Our ref: KT/2021/128077/01-L01
Registration ID: 20027842
Your ref: BC080001
Date: 31 March 2021

Application for a Development Consent Order for London Resort

Relevant Representations

Figure 17.23: Kent Project Site Baseline predicted patterns for erosion and deposition.

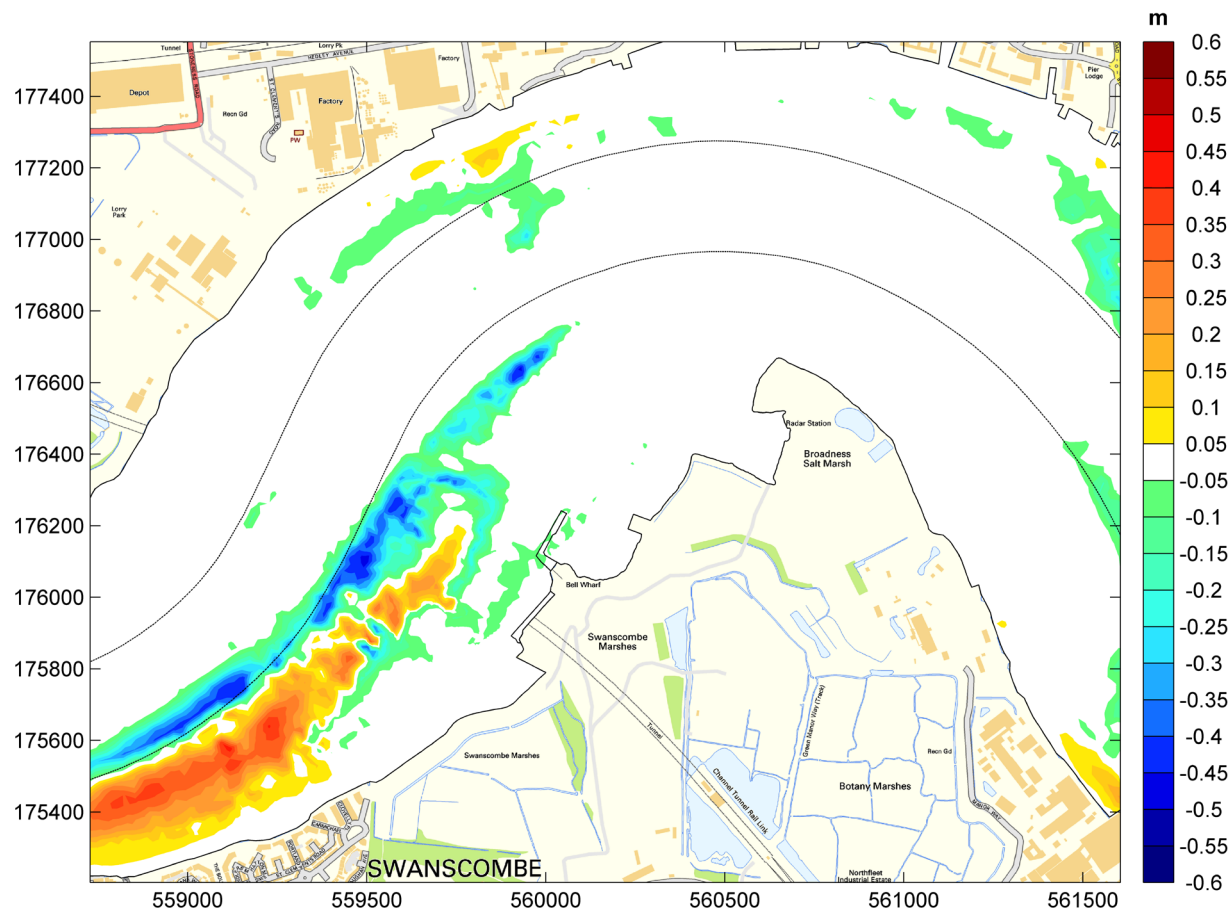
5. We expect further assessment of the impacts of the helipad use on the retained areas of open water habitat at Black Duck Marsh.
6. We need information to clarify if the existing mudflats and saltmarsh are erosional or depositional and how that links to the development impacts.
